**Subject:** SP-24-00011 Lewis - Notice of Application

RE: SP-24-00011 Lewis

**TO:** All Staff  
**FROM:** Public Works Plan Review Team  
**DATE:** August 22, 2024  
**SUBJECT:** SP-24-00011 Lewis

**RE: 202403415; SP-24-00011**

LEWIS SHORT PLAT PART OF SECTION 29, T. 17 N., R. 20 E., W.M. KITITAS COUNTY, WASHINGTON

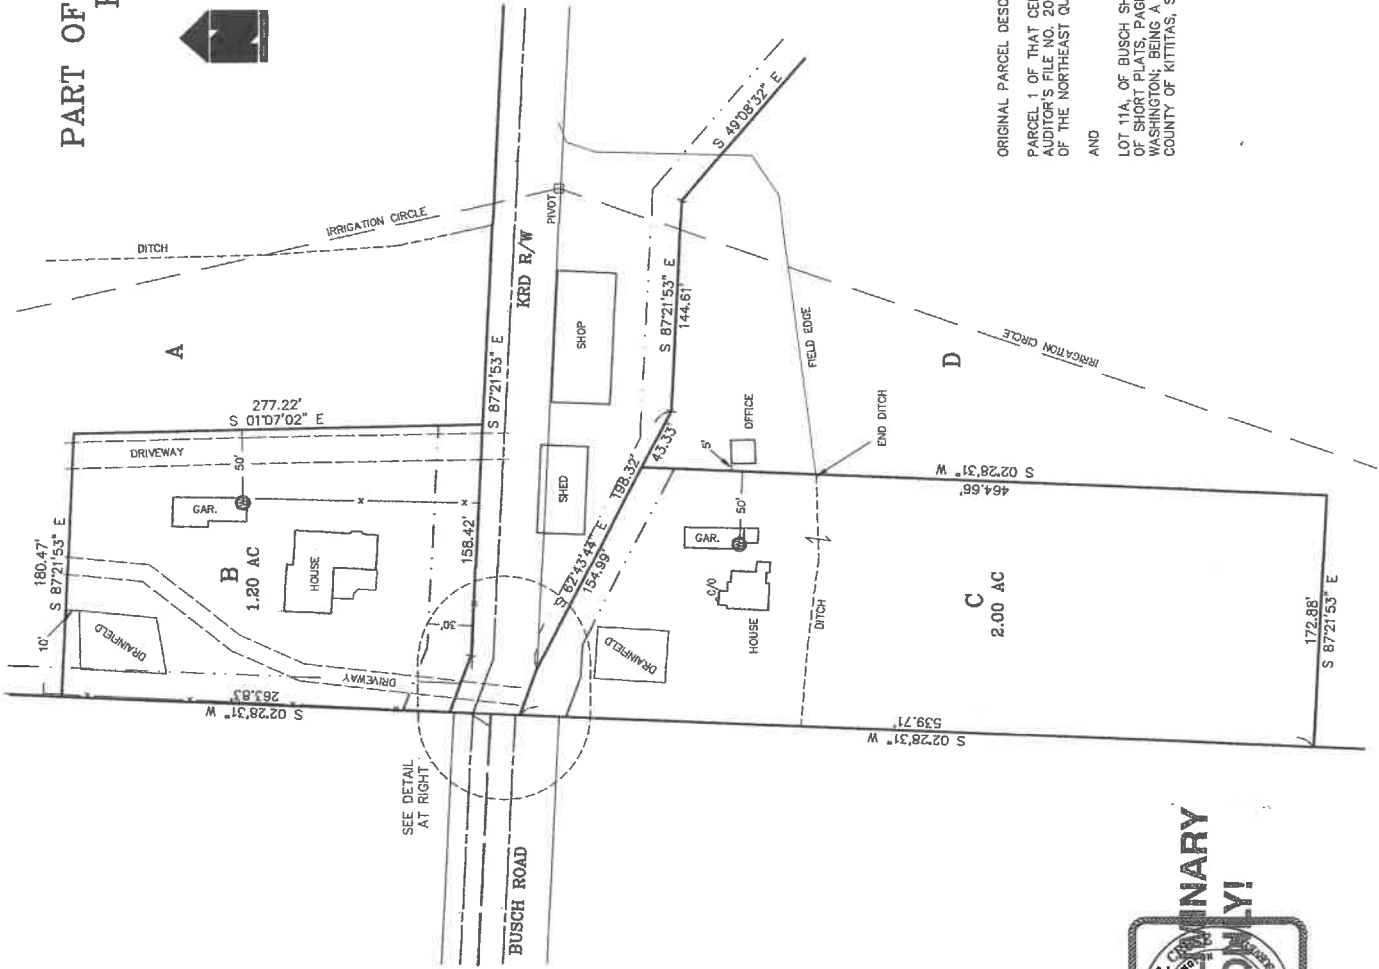
<p>Please show the width and recording information for the existing easement through the middle of Lot A.</p> <p>OF NOTE Lot closures were not reviewed as part of this submittal. Lot Closures will be reviewed at final. Title report was reviewed as part of this submittal. Ownership and legal description is fine. (JT)</p>
<b>TRANSPORTATION CONCURRENCY</b>	No transportation concurrency requirement for this project. (KAH)
<b>FLOOD</b>	The proposed short plat is not located in a FEMA identified special flood hazard area (100-year floodplain). A floodplain development permit is not required for the project. (SC)
<b>WATER MITIGATION/ METERING</b>	<p>The following comments outline the requirements for legal availability of water and metering for the proposed short plat:</p> <p>The applicant must provide legal water availability for all new uses on the proposed lots of this project, which can be provided through mitigation certificates. Prior to final plat approval and recording, the following conditions shall be met:</p> <p>In accordance with KCC Chapter 13.35.027, the applicant shall provide one of the following documents before final plat approval:</p> <ol style="list-style-type: none"> <li>1. A letter from a water purveyor stating that the purveyor has adequate water rights and will provide the necessary water for the new use;</li> <li>2. An adequate water right for the proposed new use; or</li> <li>3. A certificate of water budget neutrality from the Department of Ecology or other adequate interest in water rights from a water bank.</li> </ol> <p>All applicants for land divisions shall also submit information on "proximate parcels" held in "common ownership" as those terms are defined in WAC 173-539A-030 and otherwise demonstrate how the proposed new use will not violate RCW 90.44.050 as currently existing or hereafter amended.</p> <p>Failure to obtain mitigation before commencement of an activity requiring mitigation shall be a code violation subject to enforcement under Title 18 KCC.</p> <p><b>Final Plat Notes</b></p> <p>The following notes shall be placed on the face of the plat:</p> <p>C-1 "Metering is required for all new uses of domestic water for residential well connections and usage must be recorded in a manner consistent with Kittitas County Code Chapter 13.35.027 and Ecology regulations."</p>
